Your ref:
Our ref: 23/01088/F
Please ask for: Mrs Lesley Raby
Direct dial: 01553 616818
E-mail: borough.planning@west-norfolk.gov.uk

Details: **Demolition of existing dwelling with proposal for a new double storey dwelling at Sunview 9 Willow Drive Setchey King's Lynn Norfolk**

DRAWING NO.  
*Sheet 3*

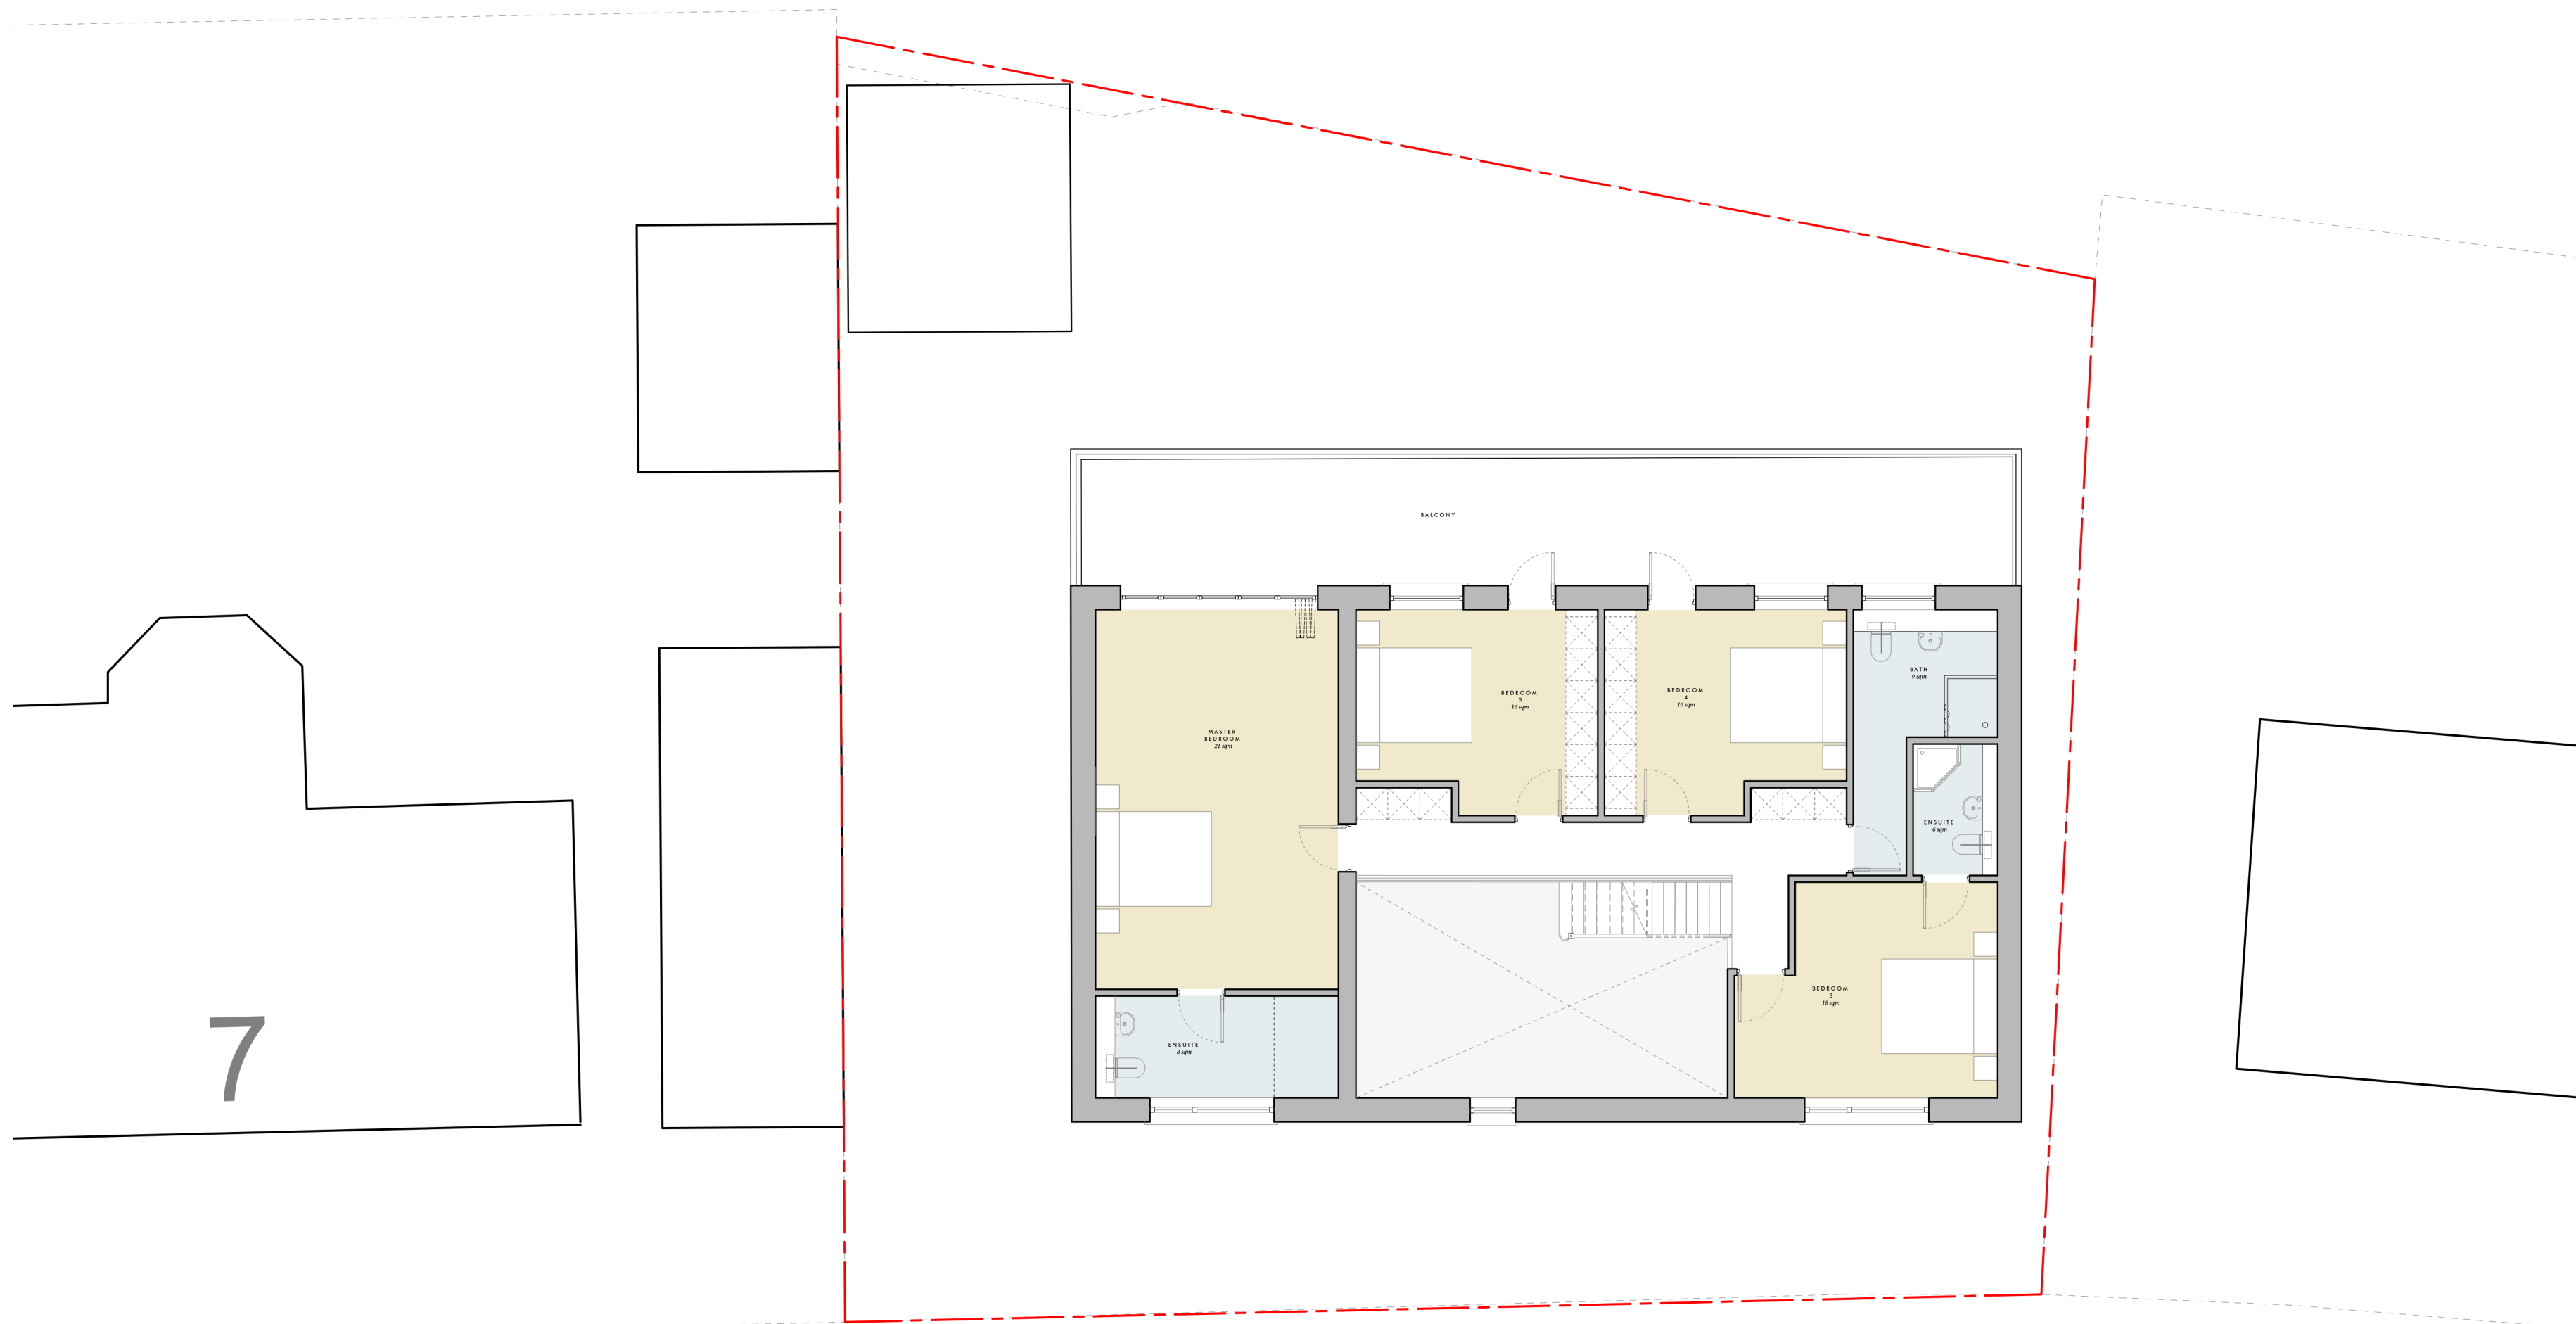
4. Provide a section through the new dwelling to show the floor levels.
5. Sheet 3 is annotated as the ground floor, it should be the first floor plan.
